CHIS ADDENDUM 1 - HERITAGE RELATED COMMENTS
COMMONWEALTH
AUGUST 2019

The following addendum responds to the heritage-related comments received from the City of Ottawa. City comments are in BLACK and the response is in BLUE.

Site Elevations

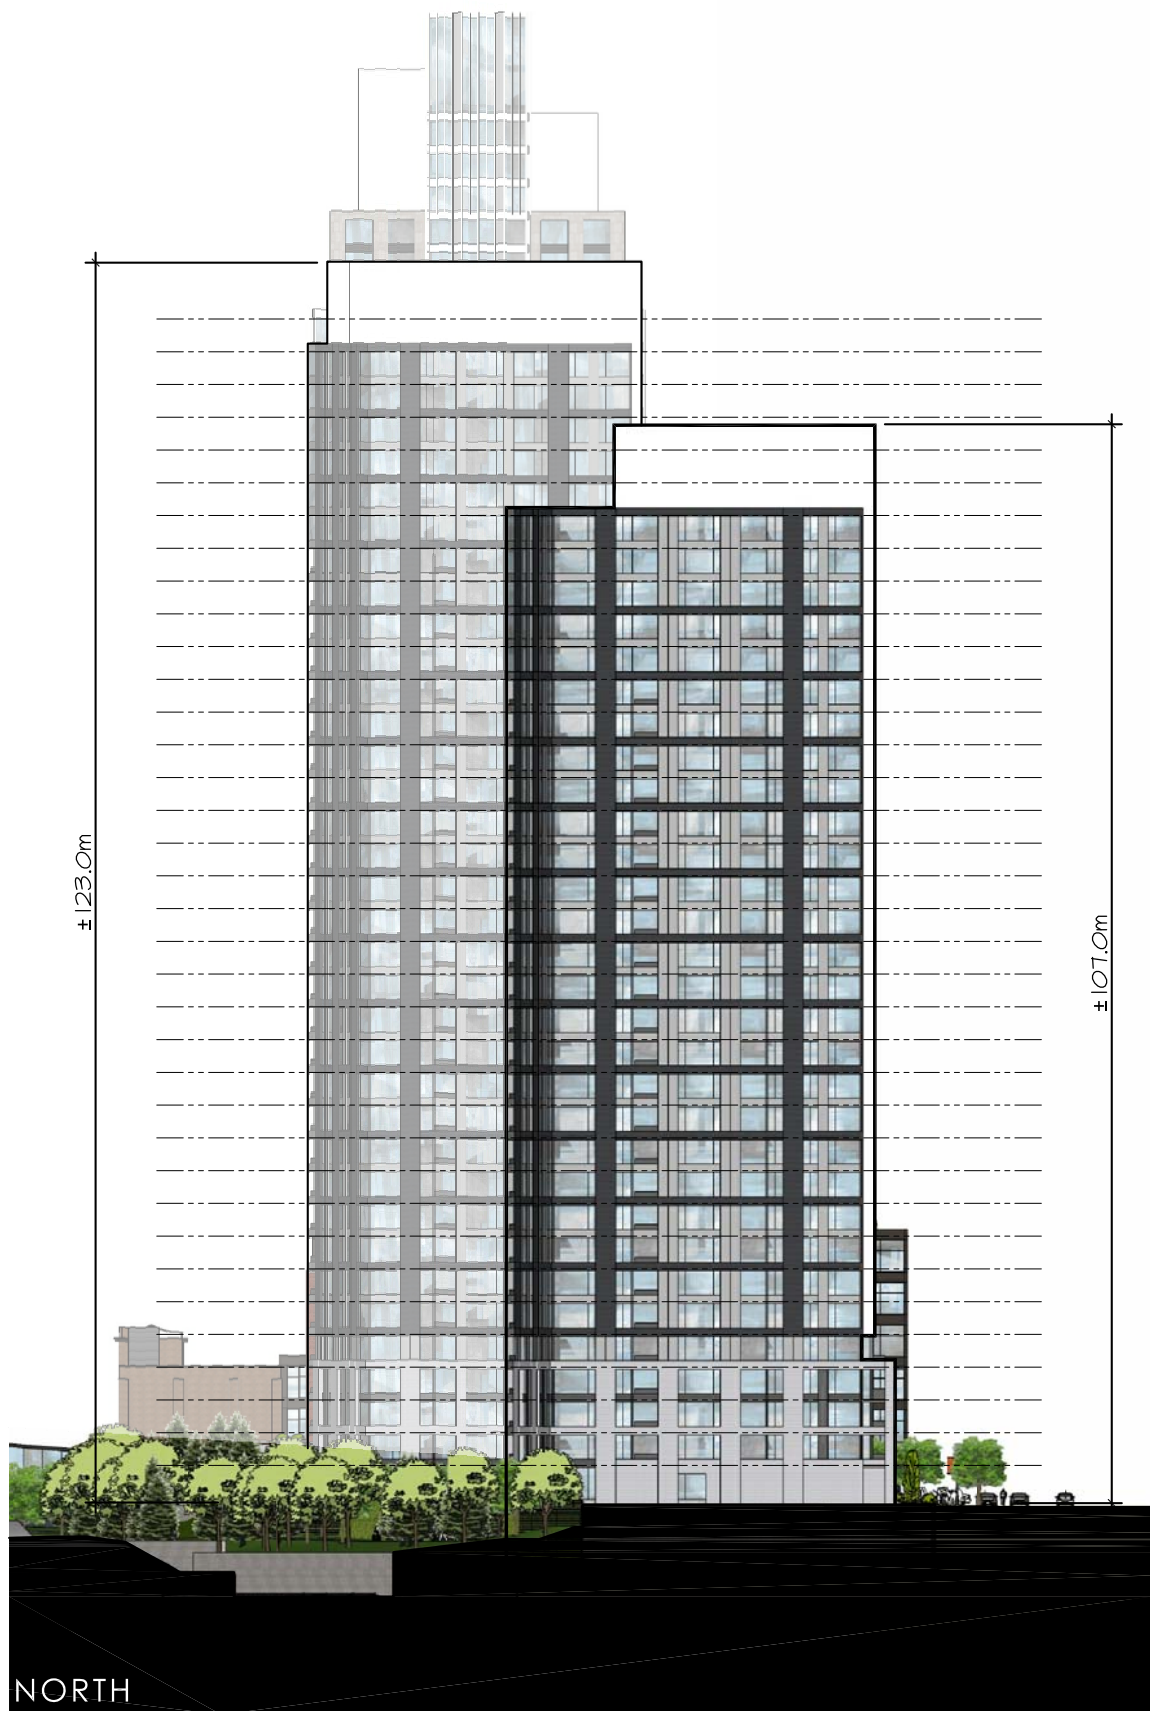
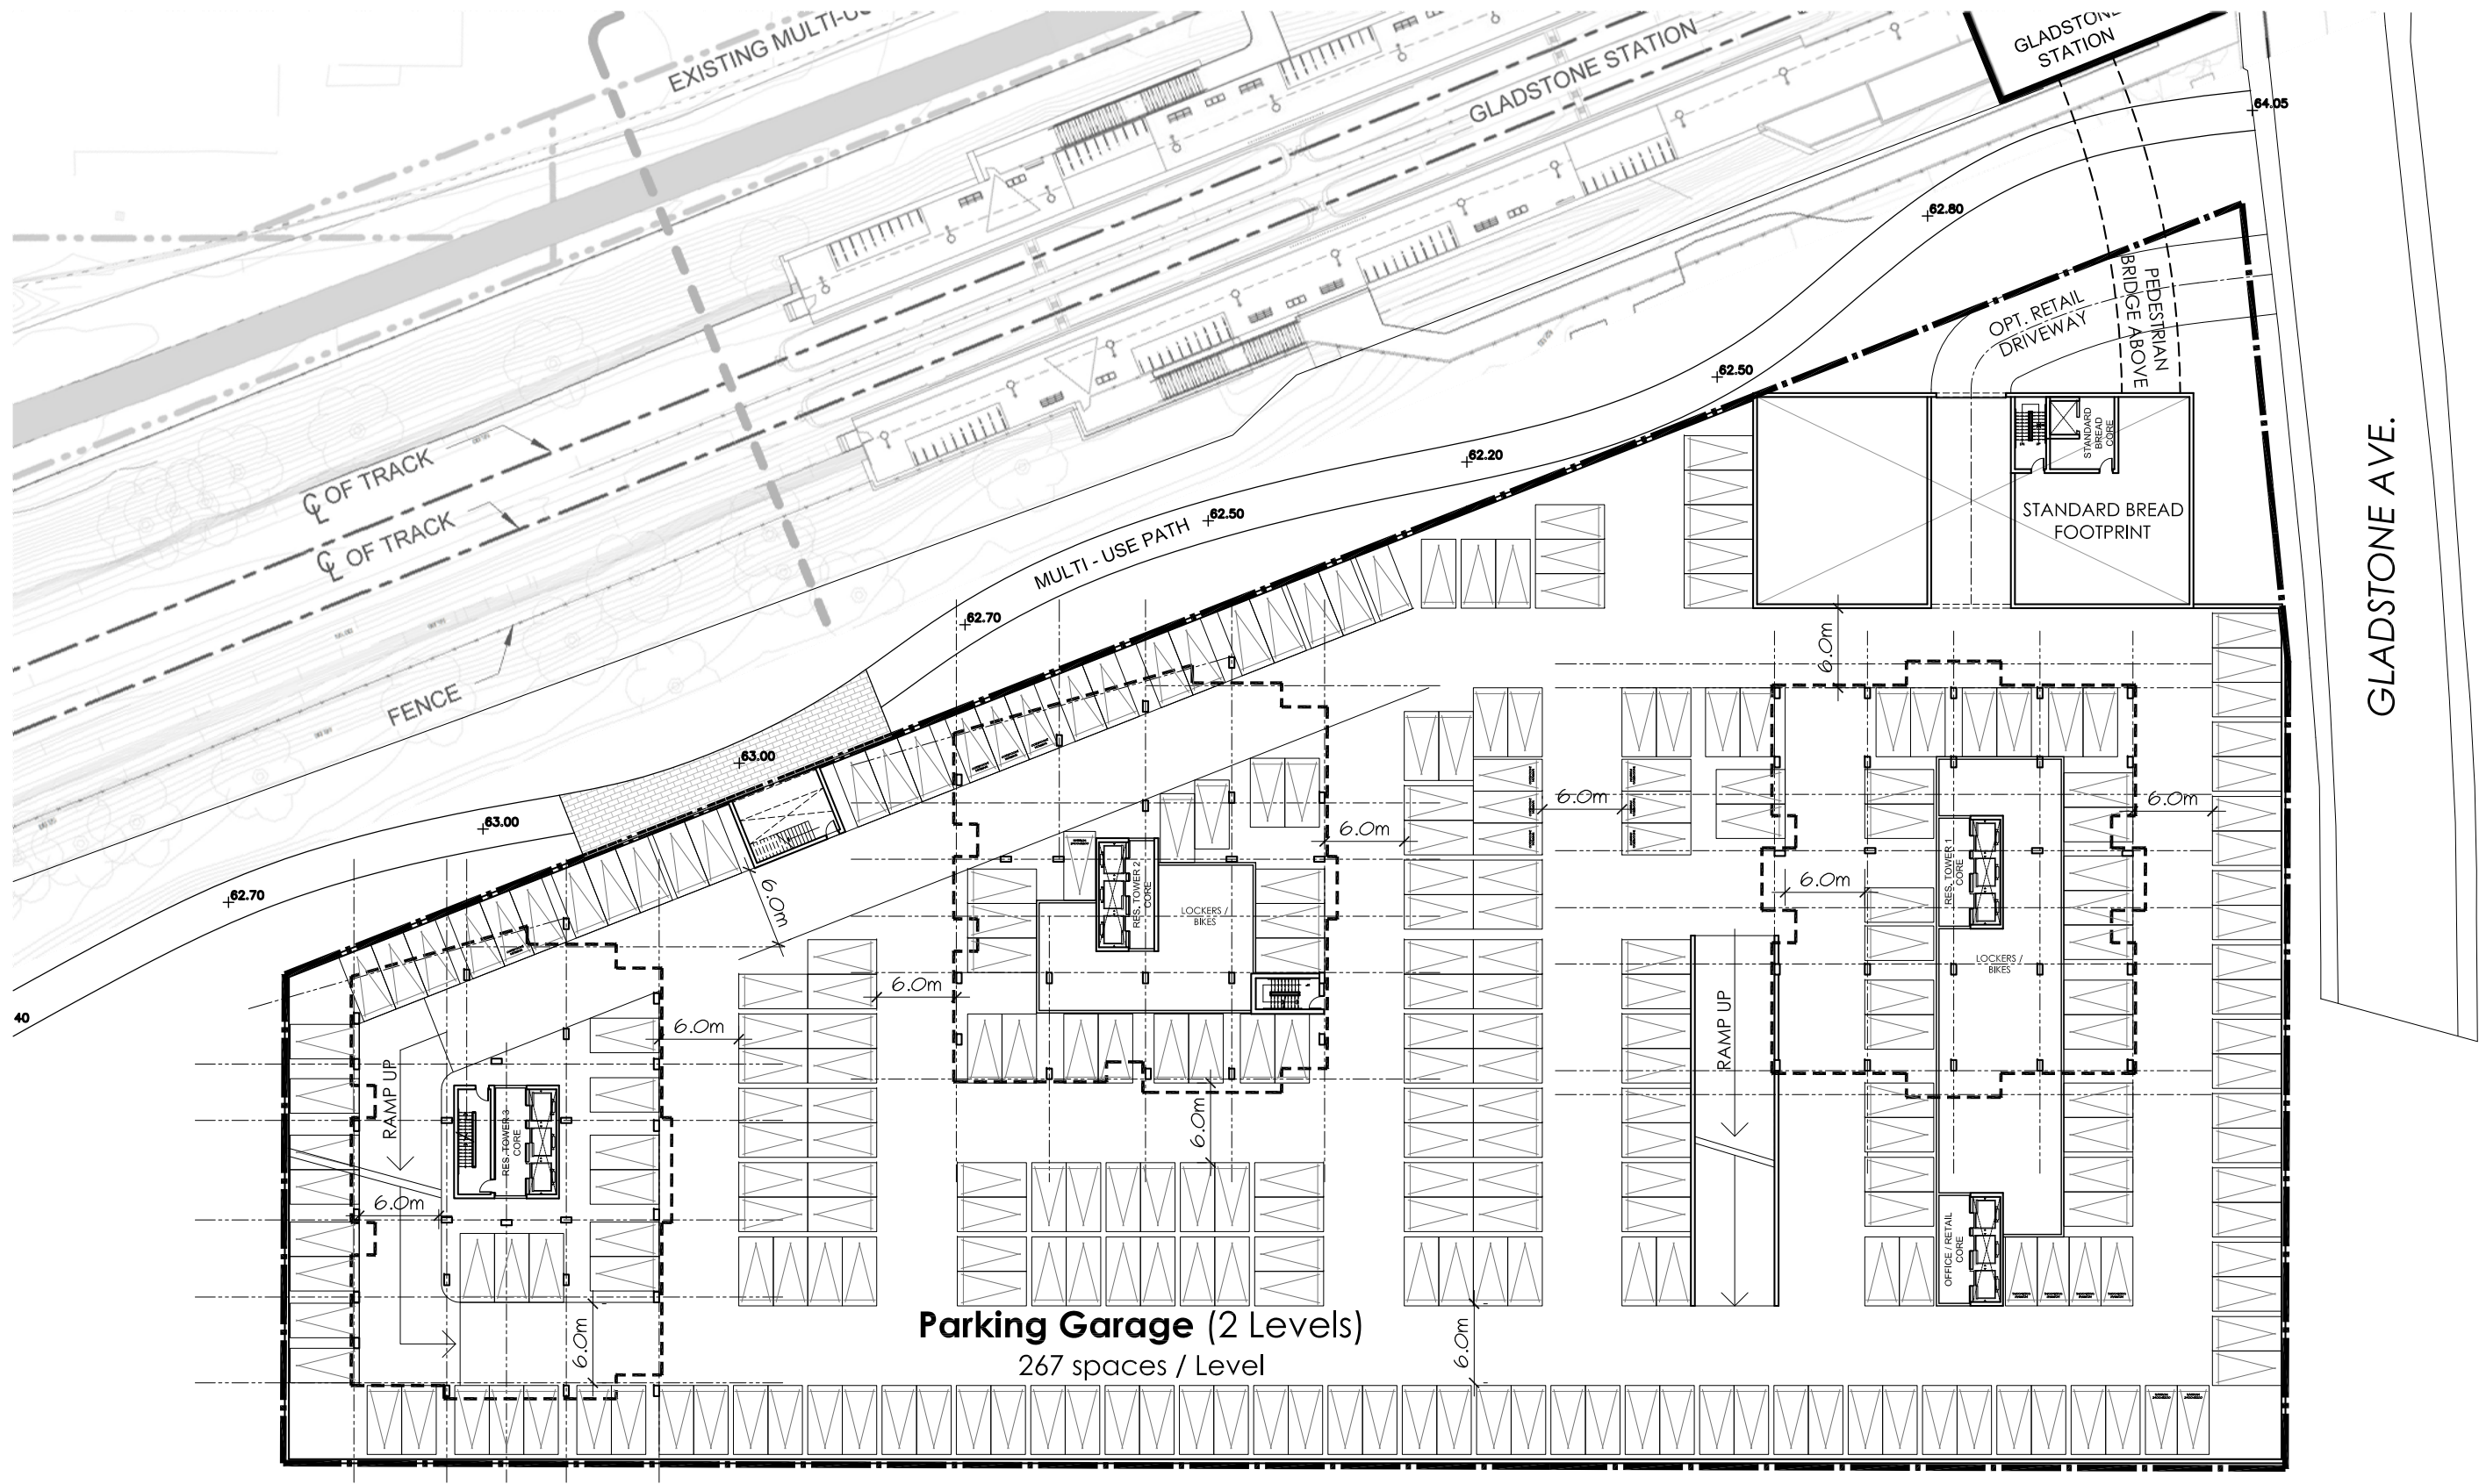
- The podium is too high as it relates to the Standard Bread Company building I would suggest a reconsideration of the scale and expression of the podium to provide a gentler transition down to the heritage building.
- The Podium is reduced in height to 5 storeys and setback further to match the Standard Bread Company building façade. The link between the podium and the Standard Bread provides a more distinct separation.

- The articulation of the façade requires more consideration/refinement to ensure that it is compatible with and provides a sympathetic transition to the east.
- A brick façade is being used on the podium of Building 3 so that historical material palette is consistent across the development.

The siting has been revised to provide more prominence to the Standard Bread Building. The podium of Tower 1 has been set back to align with the setback of the Standard Bread Building, and podium height reduced to five storeys. The link between the podium and Standard Bread Building has been reduced to three storeys and the north elevation of the link has been setback further to provide a more three-dimensional view of the building when seen from the west. There is the potential to reduce the link to two storeys, which would further enhance the prominence of the Standard Bread Building when viewed from Gladstone Avenue.

Figure 1: Revised Site Plan

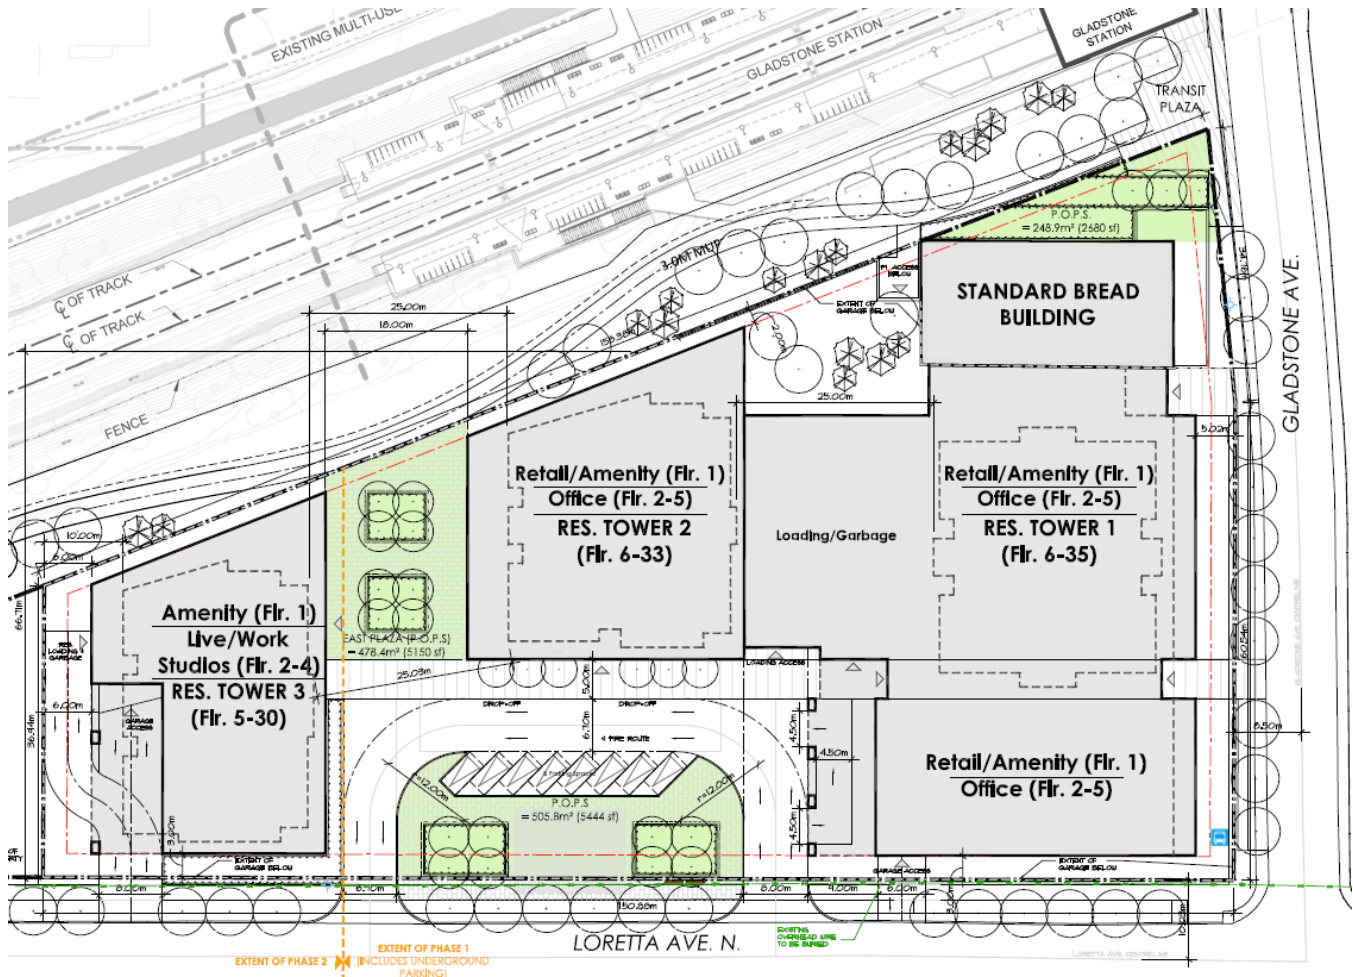
- In order to protect the landmark status of the heritage building and to provide additional “breathing room,” consideration should be given to pushing the tower further to the west?

Tower 1 has remained in the same place; however, broader design changes have mitigated the overall impact of the massing, in the process making the Standard Bread more of a focal point. The addition of POPS space adjacent to the heritage structure instead of vehicular drive aisle provides better framing and possibility for a more prominent building entryway along Gladstone.
